Our ref: Fairfield Showground Community and Events Centre (SSD-73365208)

Subject: Fairfield Showground Community and Events Centre (SSD-73365208) - Response to Submissions

Figure 2 Location of New Pick-Up and Drop-Off Facility

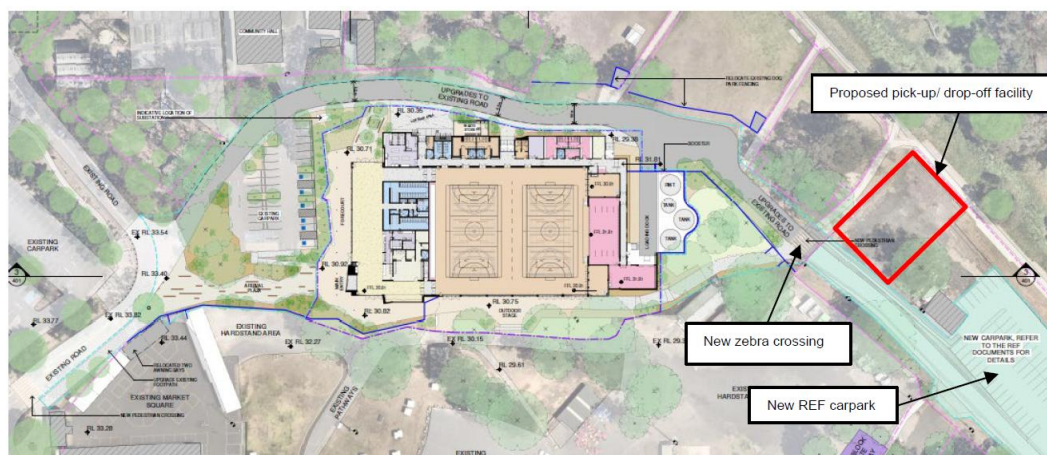
- No pick-up/drop-off location is nominated. Provide details of drop-off and pick-up arrangements and assess the suitability and safety of the arrangements.

Figure 3 Location of Parking Areas CP-2 and CP-3

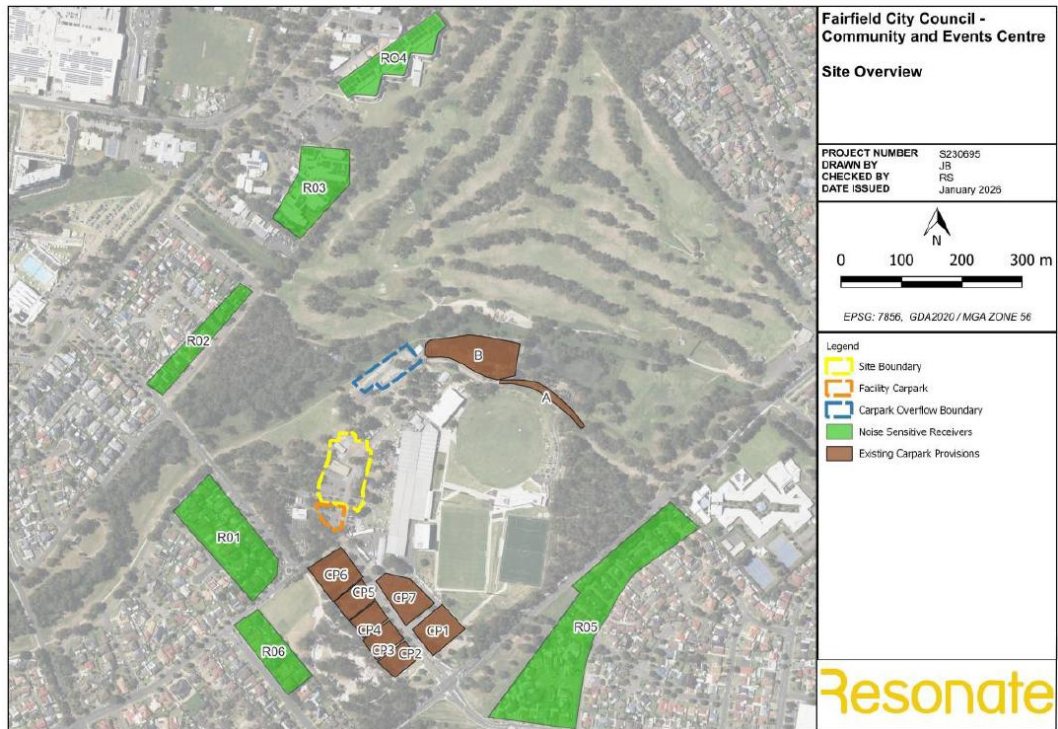
- Section 7.1.4 of the NVIA only assesses carpark use noise from two parking areas. It is likely that all carparks at the showground will be used for major events at the site. Update the assessment to consider noise with all showground carparks in use.
